From: Anita Gardner <Anita.Gardner@arun.gov.uk>
Sent: 02 November 2021 14:33
To: Planning.Responses <Planning.Responses@arun.gov.uk>
Subject: FW: Dappers Lane, Angmering -A/ 210/21/DOC

From: Anna Gillings [REDACTED]
Sent: 02 November 2021 14:28
To: Anita Gardner <Anita.Gardner@arun.gov.uk>
Cc: Shaun Letchford [REDACTED] Sam Rous <[REDACTED]> Emma Patchell
[REDACTED]
Subject: Dappers Lane, Angmering - 210/21/DOC

Subject: RE: Dappers Lane - Drainage

Scale NTS	Date Jul '21	Drawn JS	Checked SL
Drawing No A360-08			Revision B

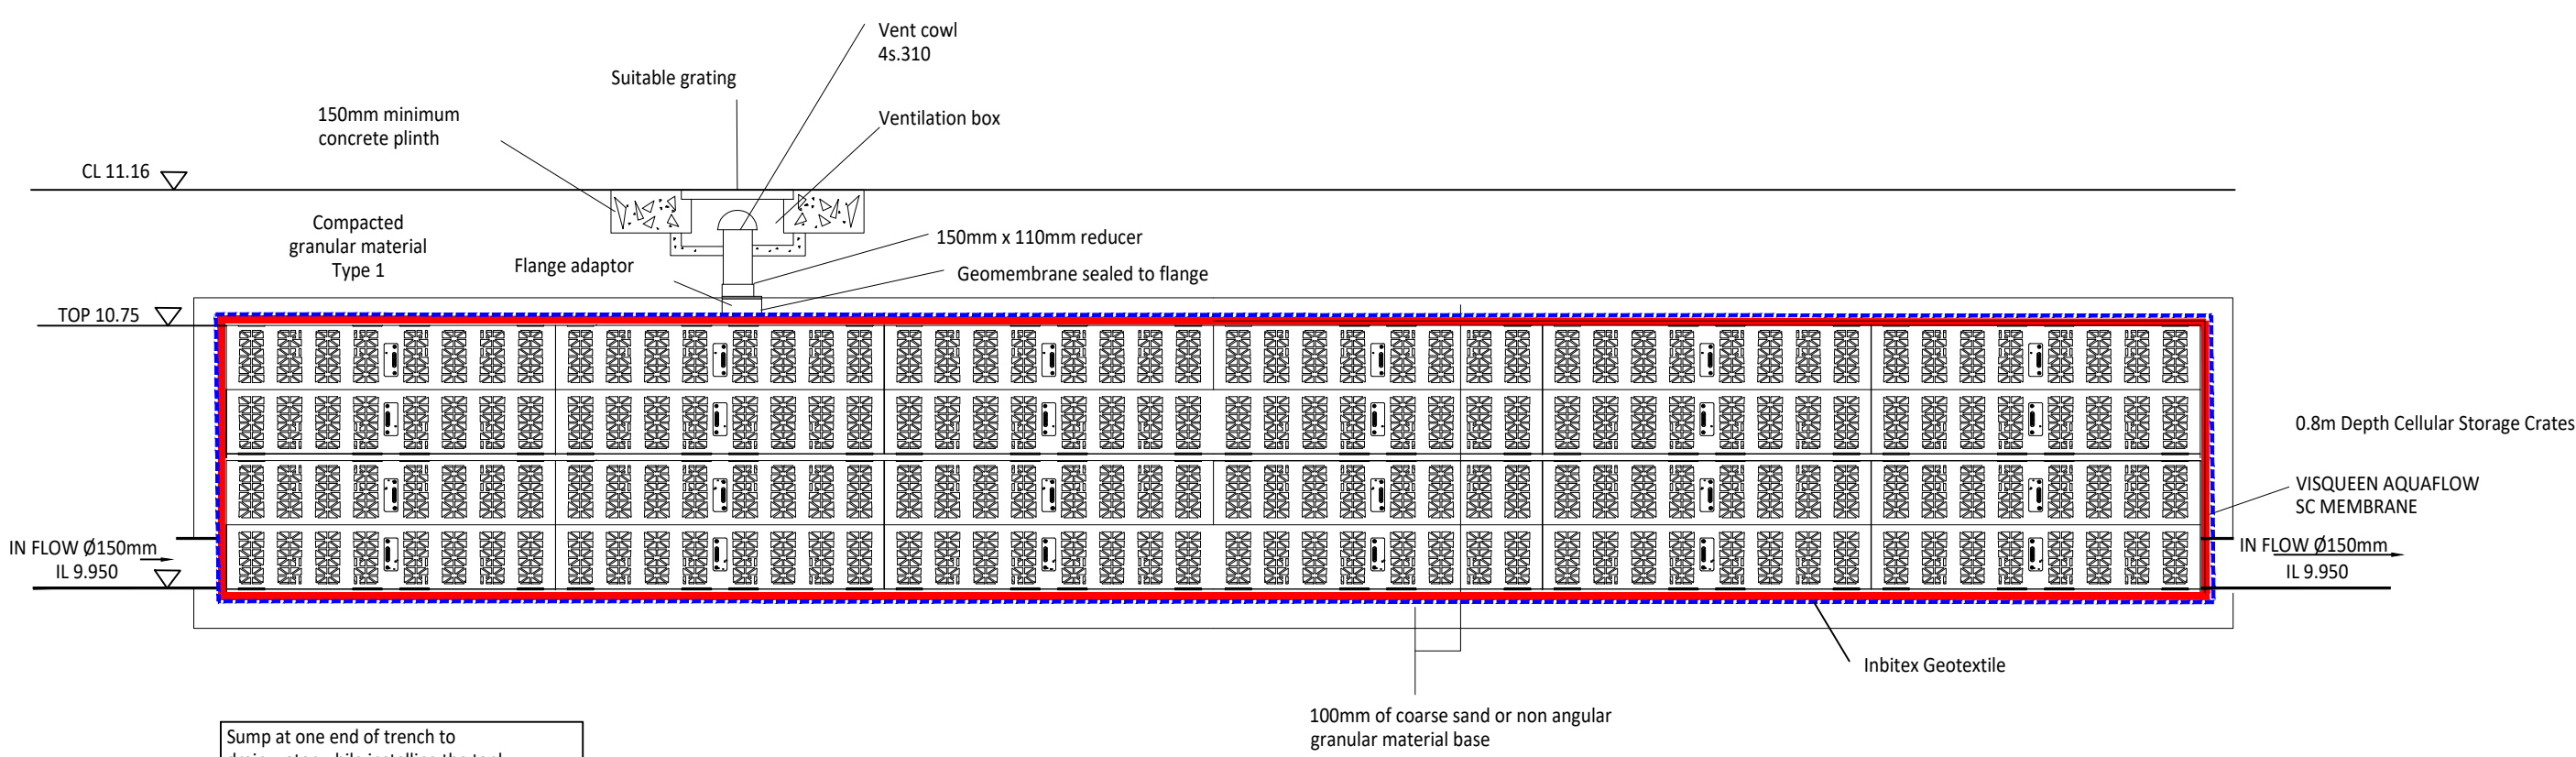
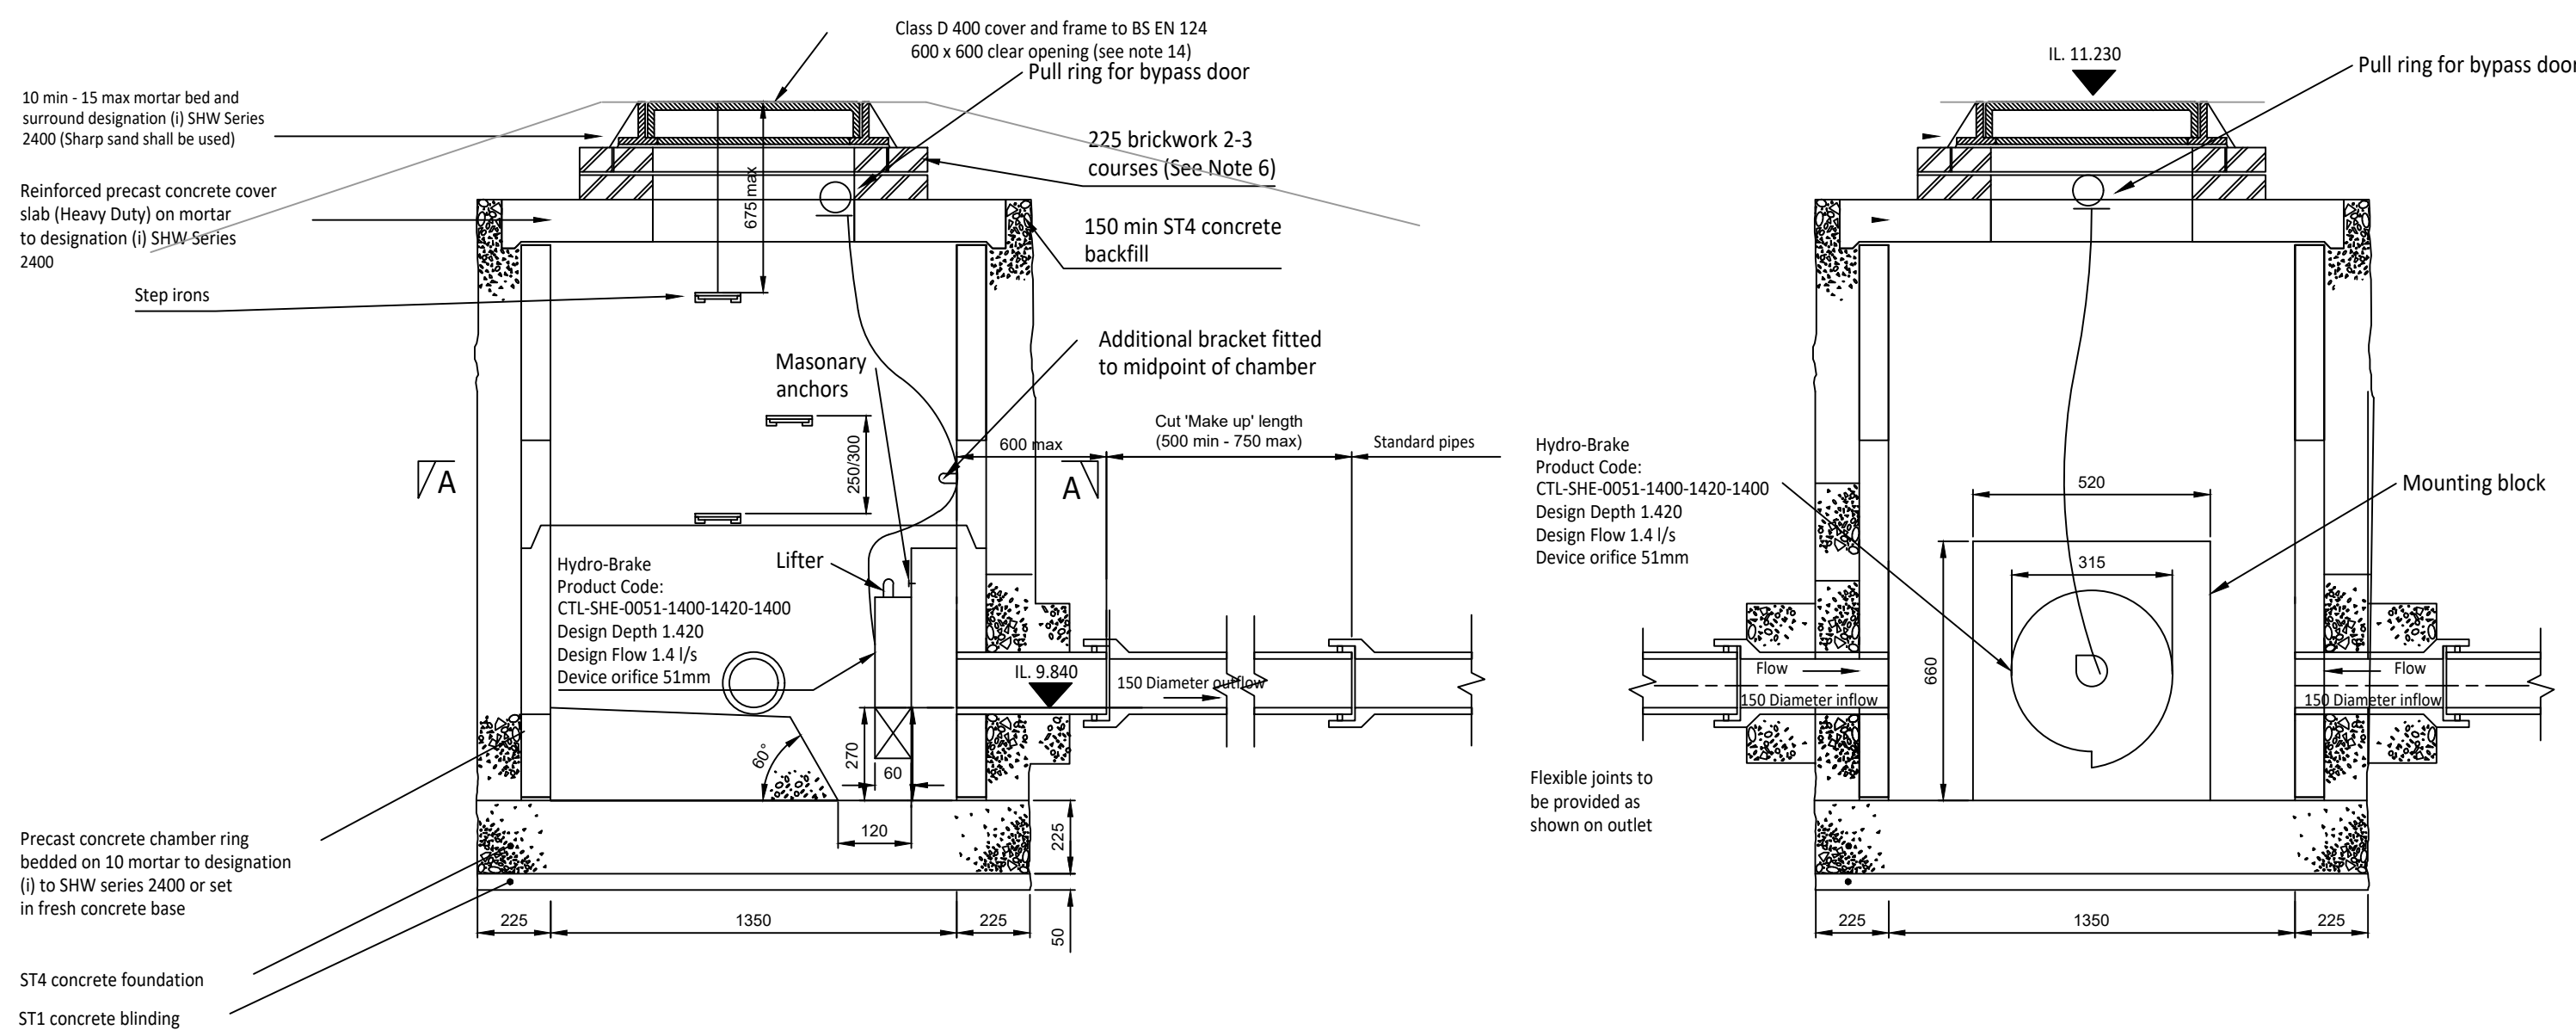
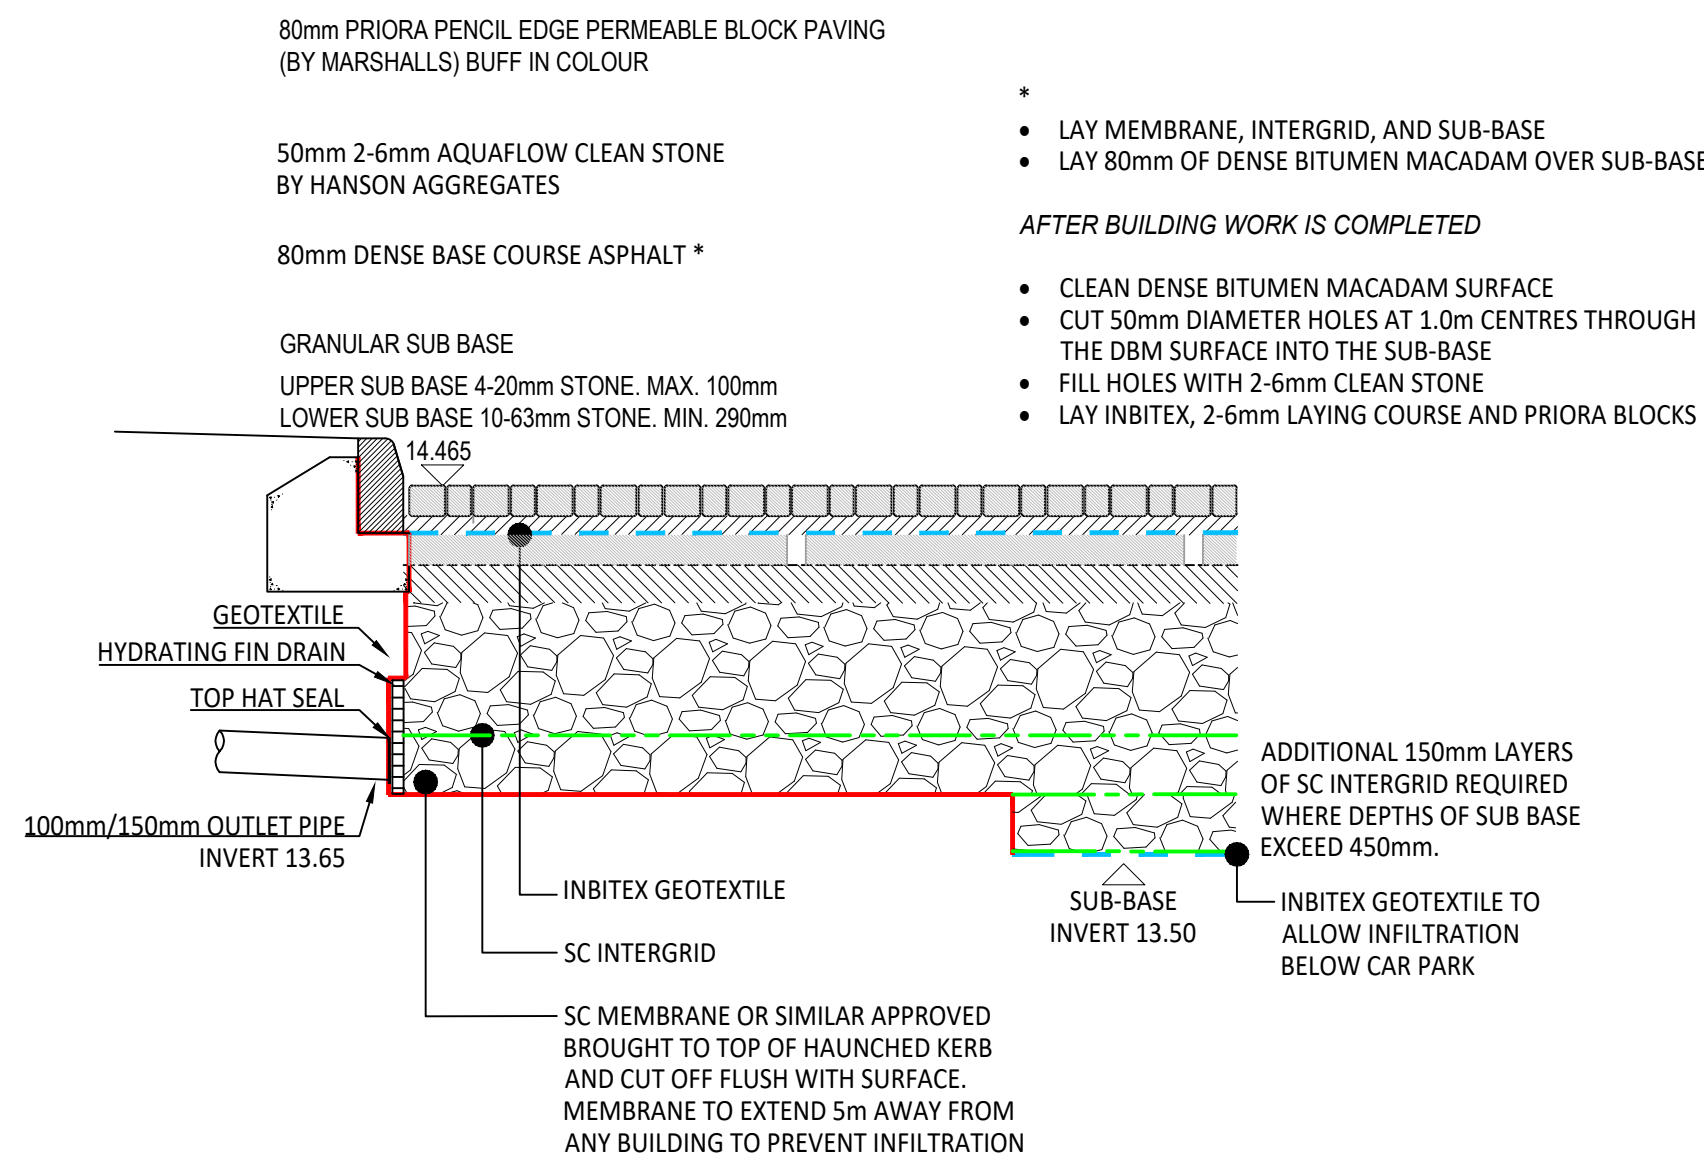
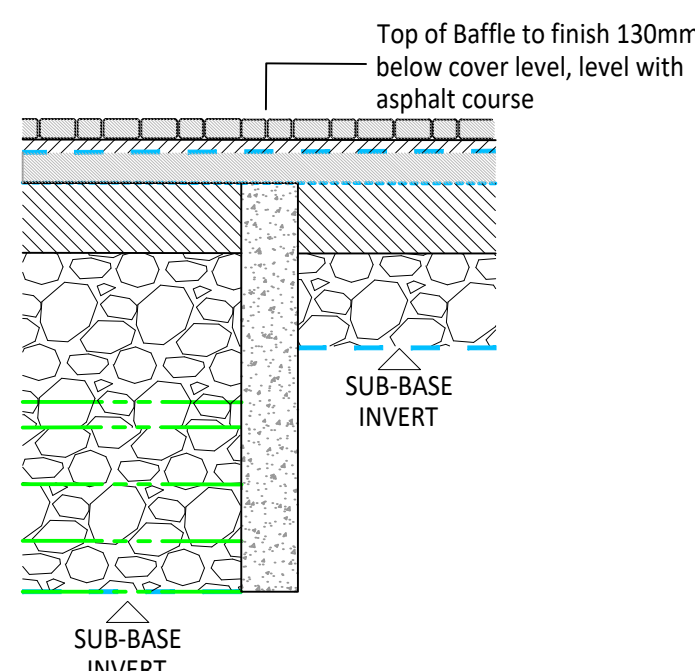
5. Please provide construction detail drawing showing swale cross section, long section, ACO inlet detail in relation to swale, connection between swale and ditch. *Await comments regarding proposed connection to ditch from a land drainage consent perspective.*

6. A construction detail drawing of the permeable paving is required. Including additional details showing diffuser block connections, and baffles. *Detail showing distribution tank does not appear to have been supplied. Awaited*

7. Please provide construction detail of permeable paving which is shown to not have a permeable sub-base. *Is this shown by the area with the SC membrane on the permeable block paved car park detail?*

Many thanks for your comments. Please find attached the completed Ordinary Watercourse Land Drainage Consent which I believe is for Paul Cann (copied in). I have also updated A360-08 to address your comments regarding the distribution tank (point 6). With regards to your question on point 7 the SC membrane is noted to extend 5m away from any building on the blocked paved car park detail and also on the drainage strategy layout (A360-01). I have attached all drawings and calculations for your convenience, however please note that only drawing A360-08 has been updated.
